Bulk Recovery Solutions Pty Ltd – Ingleburn Facility – SSD 8593

I refer to the email dated 7 June 2019 from Jessica Fountain to the Environment Protection Authority (EPA) regarding the notice of exhibition for the Ingleburn Resource Recovery Facility under SSD8593 (Proposal).

MEGAN WHELAN
Unit Head Waste Compliance
Environment Protection Authority

VEHICLE TURNING PATH
HEAVY RIGID VEHICLE (12.5m) INTERNAL DROP OFF
16 KERR ROAD,
INGLEBURN
BRS

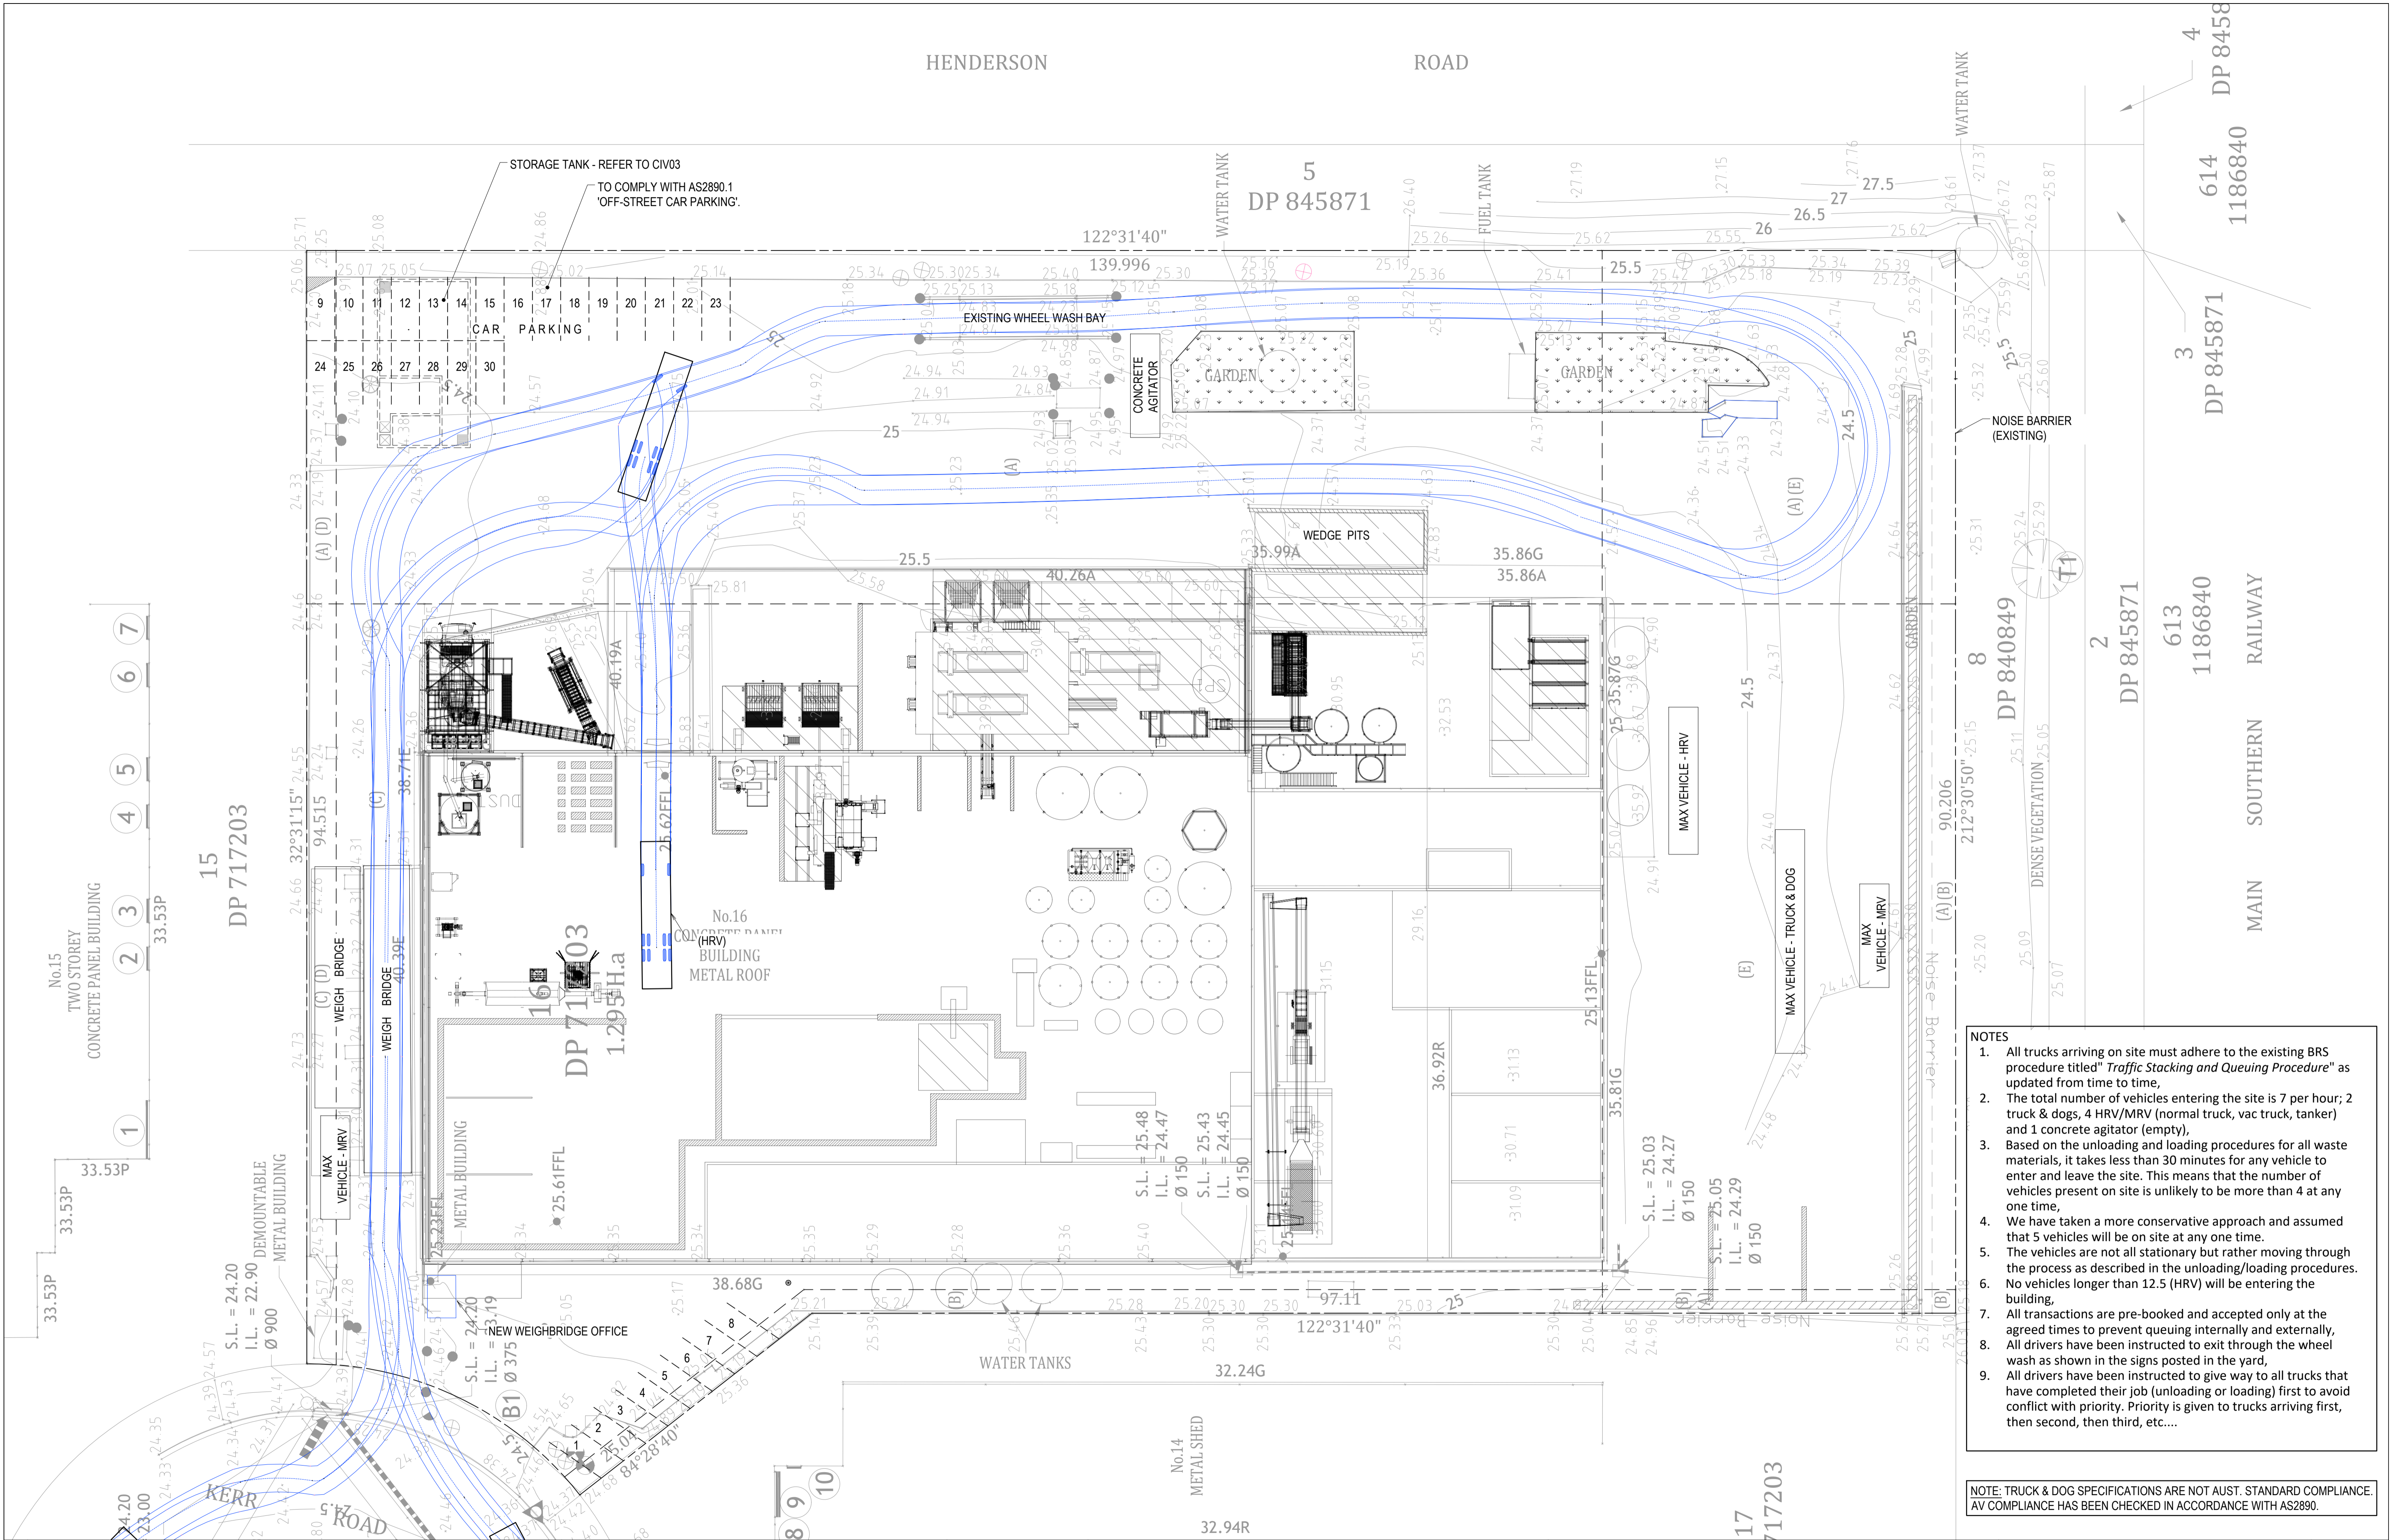
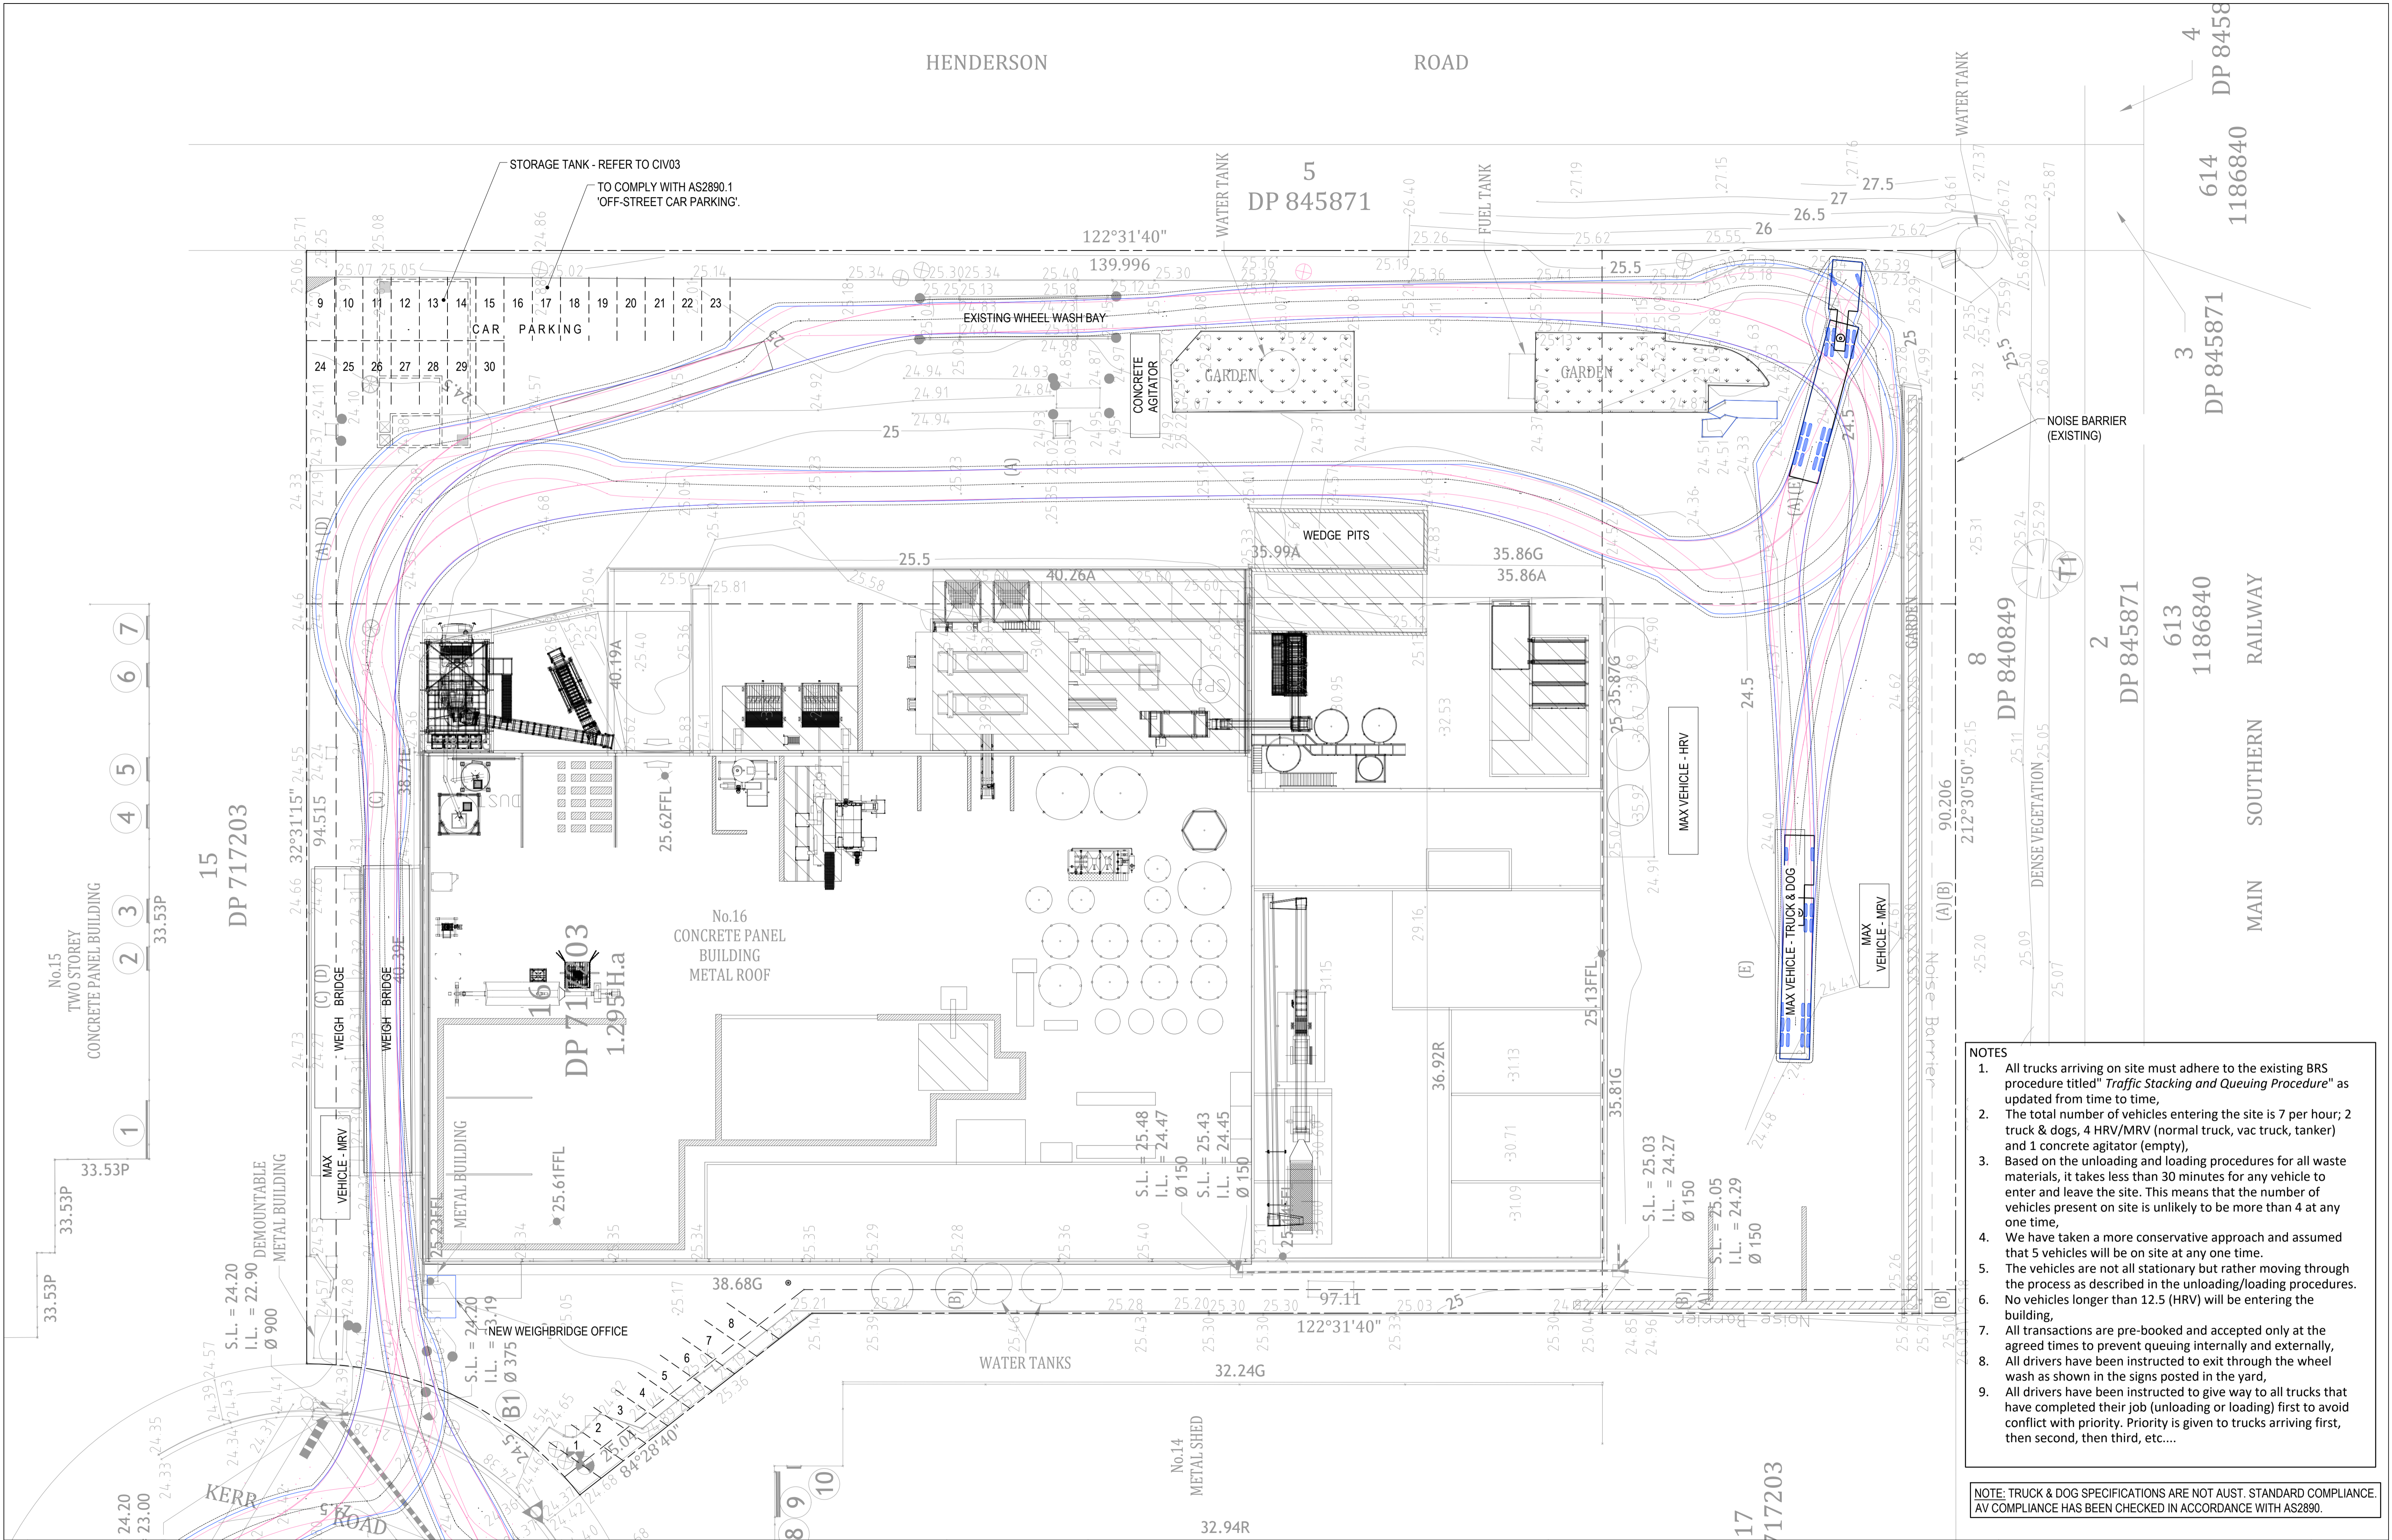
- A number of the plans submitted by the proponent detailing vehicular movement within the site show vehicle paths directly through the nominated receivals area for solid waste. We require further information detailing how the proponent will meet the EPA's minimum standards for managing construction waste in NSW, given the limited space available.
